Comments for Planning Application 23/01165/FUL

Address: Pilot House Embankment Road Bembridge Isle Of Wight PO35 5NR

Proposal: Demolition of dwelling & commercial building; proposed replacement dwelling (C3 (a) Dwellinghouses) & 19no. industrial units (B2 General industrial & B8 (storage or Distribution)

Name: Bembridge Parish Council

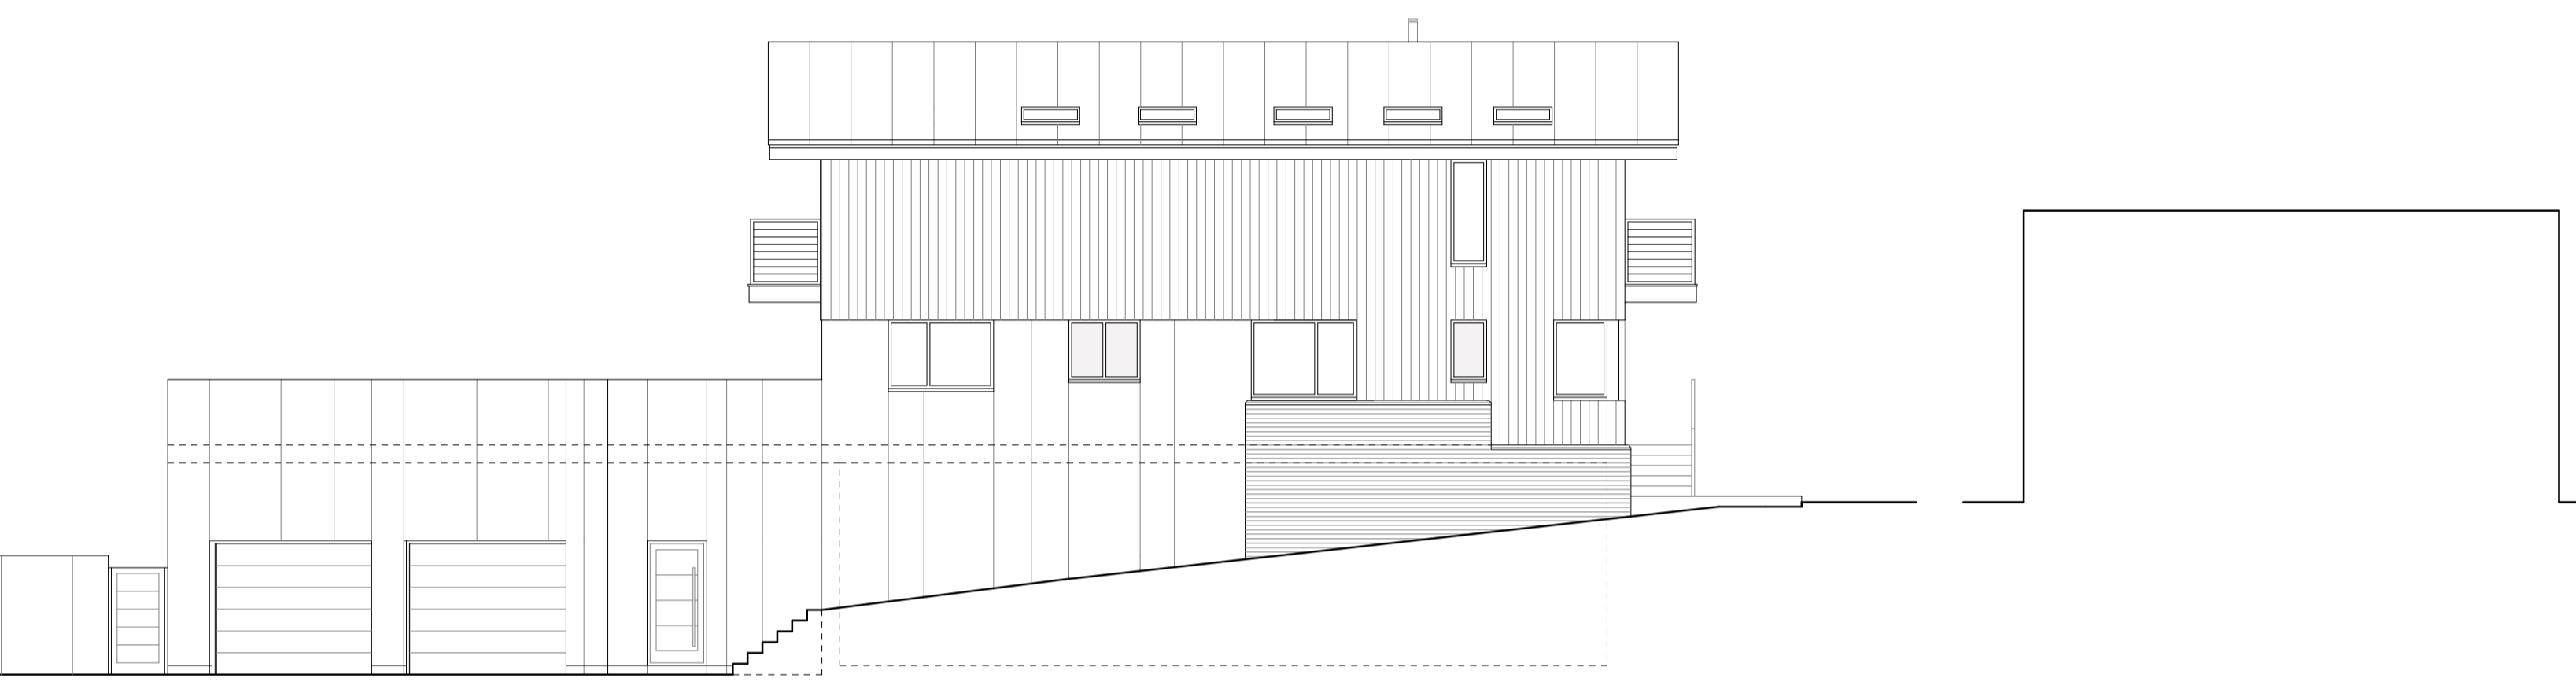
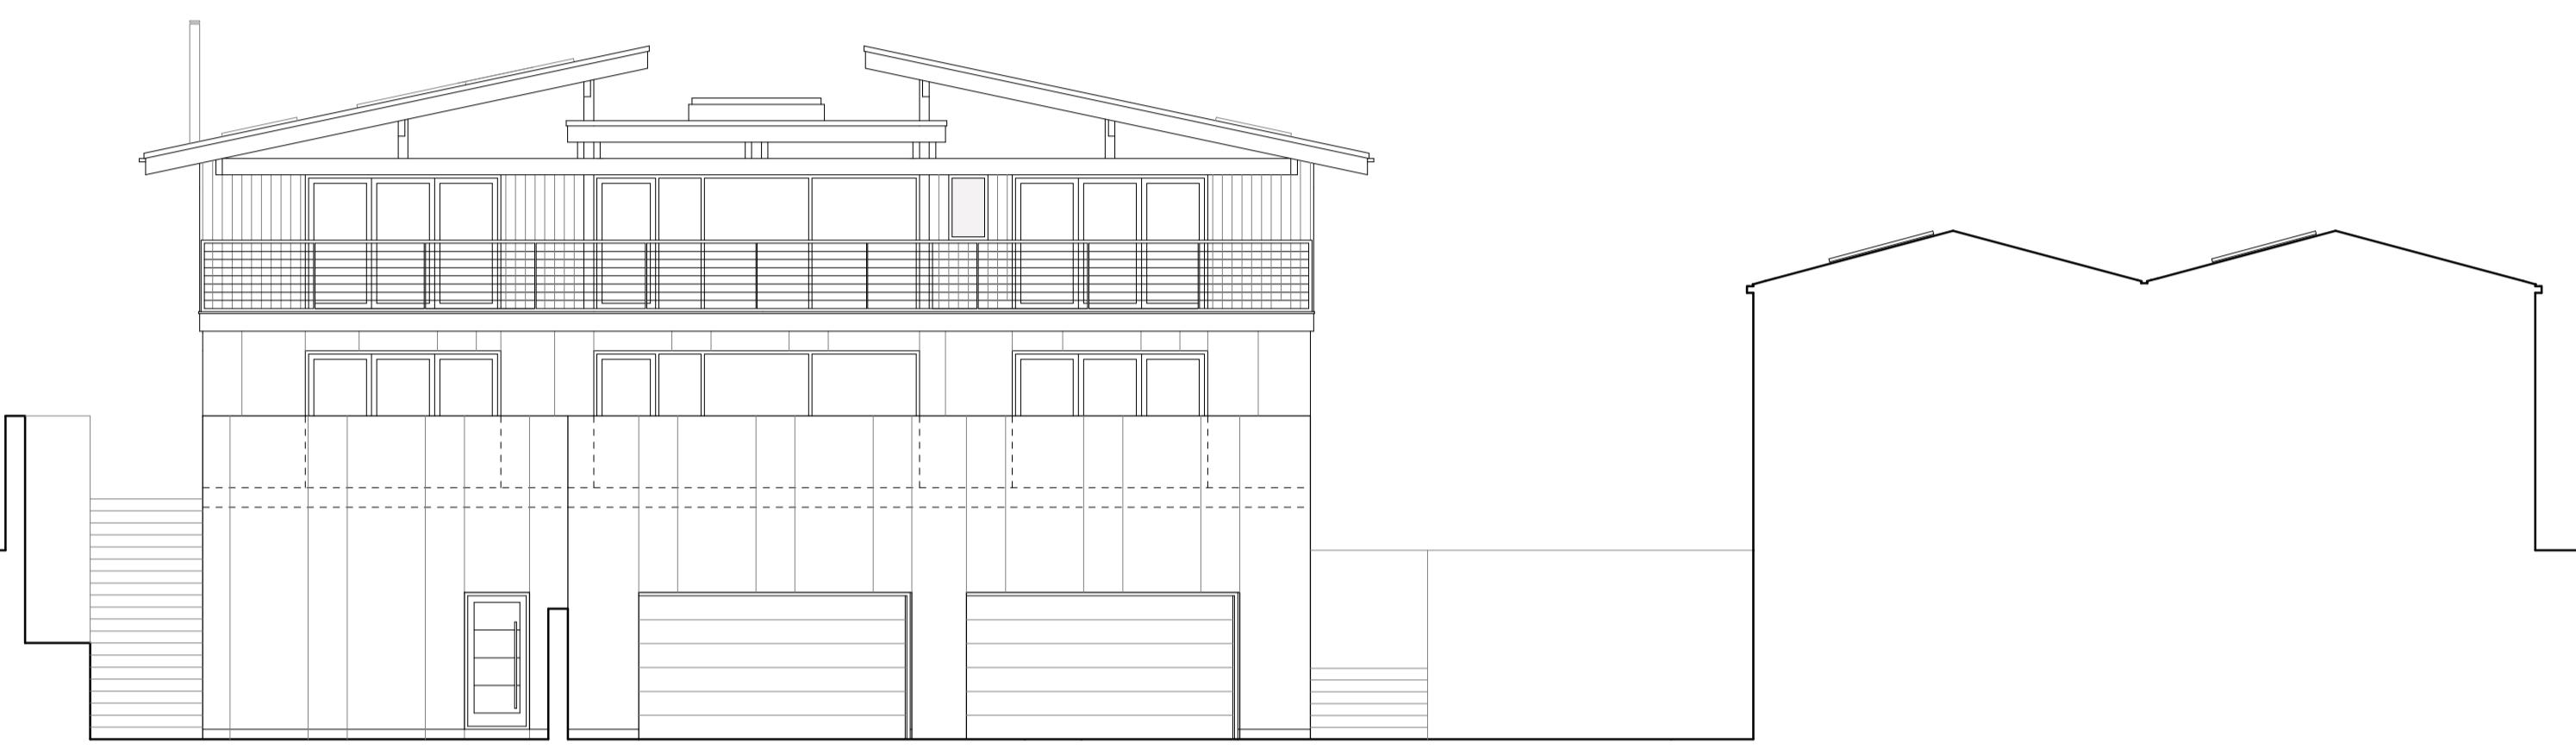
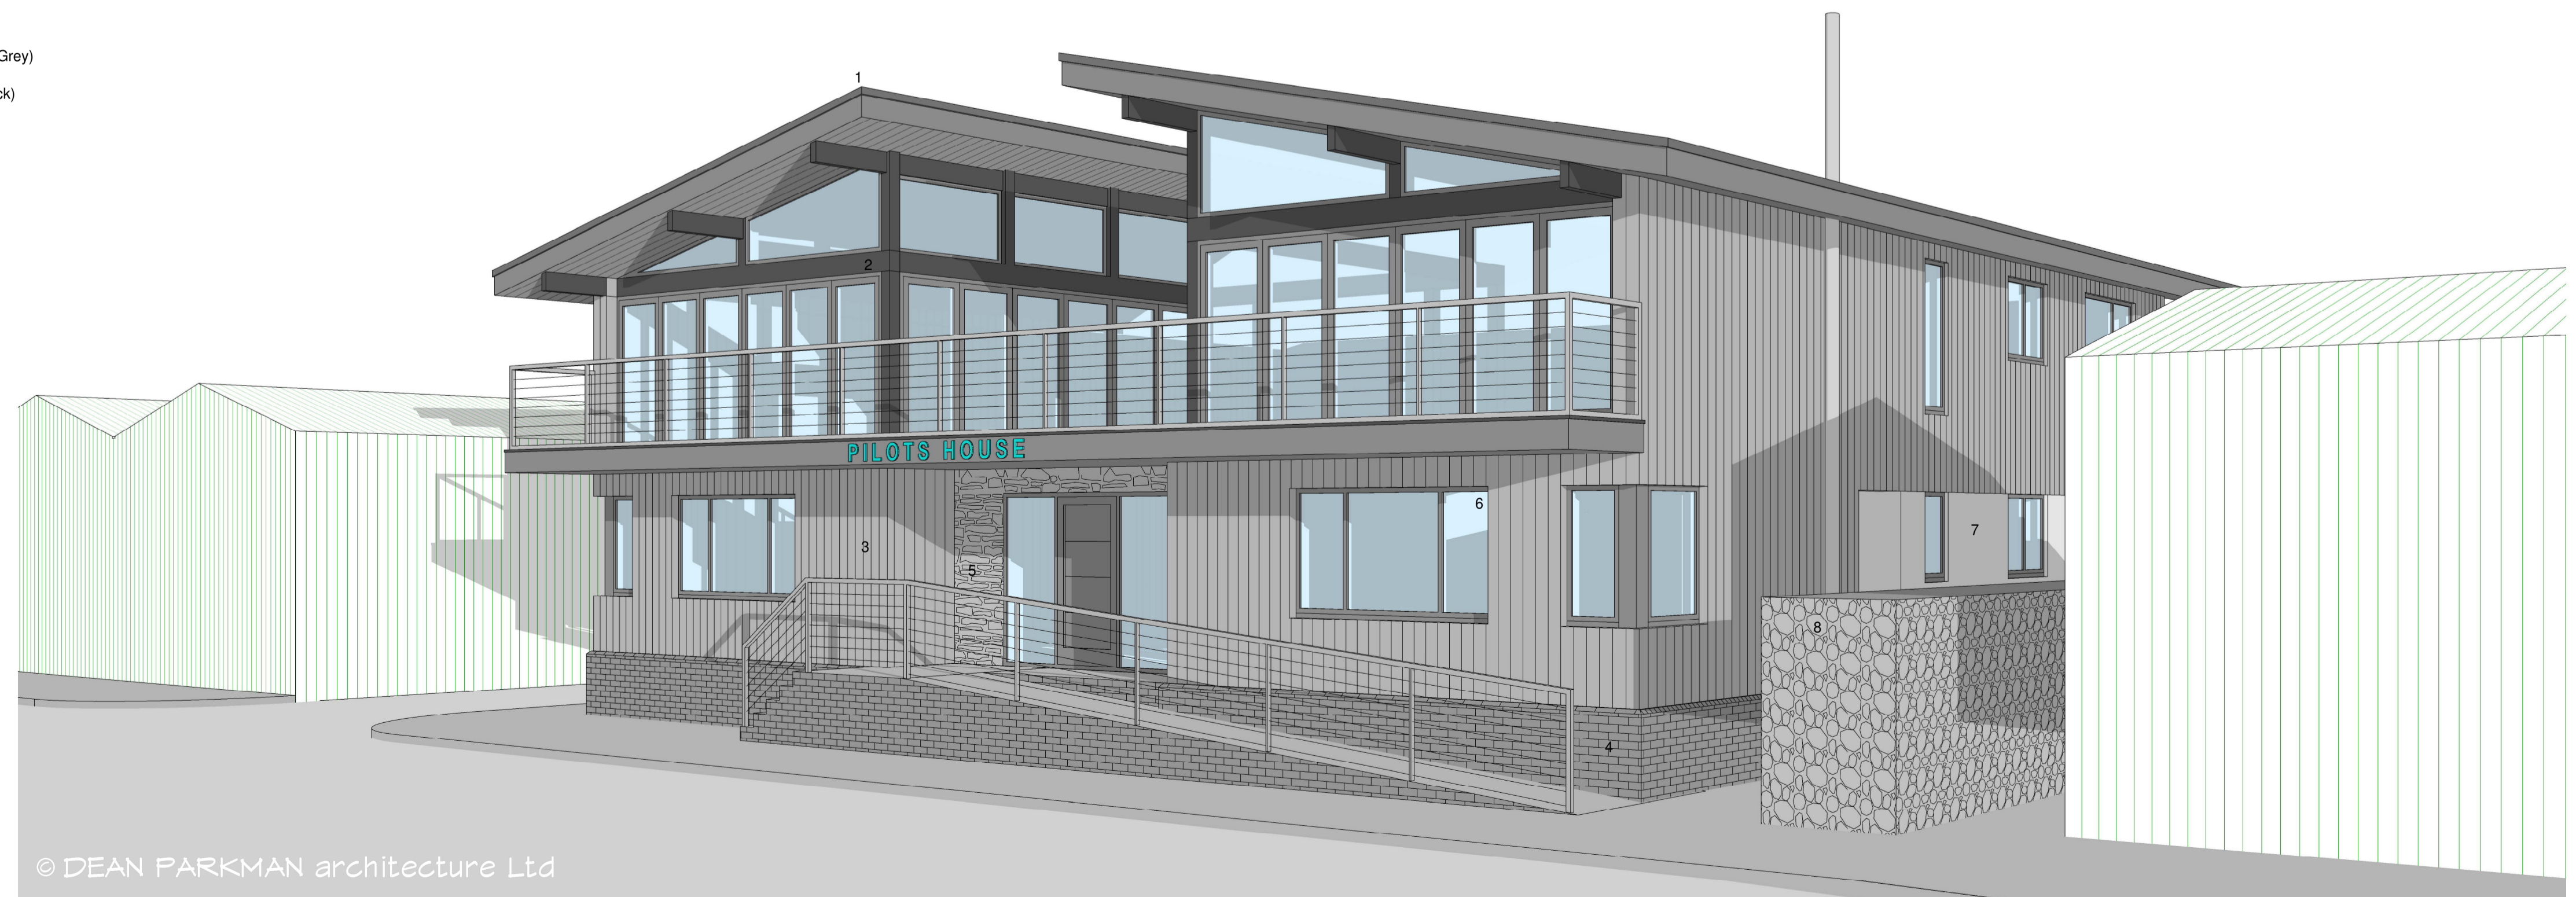
The Council believe that the new dwelling to replace the current Pilot Boat is overdevelopment of the site. The new dwelling is enormous and will dominate the area. It is right on the road and although there is a small piece of pavement, the current owners have felt the need to erect

bollards to protect their property. Therefore, building such a large dominant building so close to the road will detract further from drivers' sight perceptions. It is known that the property has a basement so to build a 5 bedroom property over this would need significant strengthening, not mentioned. The only amenity for this property is a roof terrace and balcony. There is no garden space commensurate with a dwelling of this size. Furthermore, there will be increased light and noise pollution to the lagoon.

BLOCK PLAN

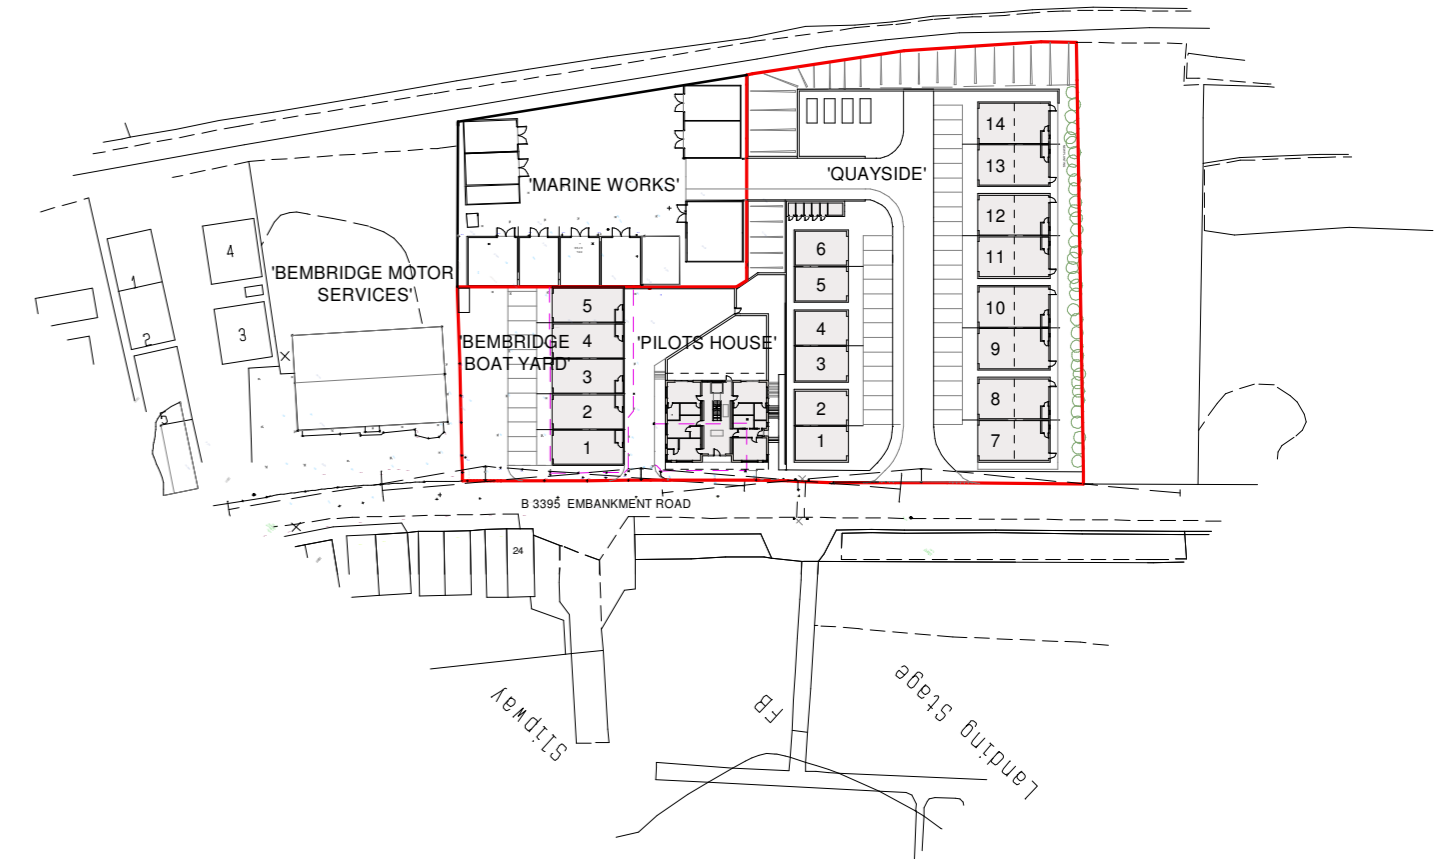
The Council believe the access points are not safe. IRs recommend refusal due to the sight lines and the Council concur with this assessment. The stated car parking is also not clear as the plans appear to show more spaces than stated.
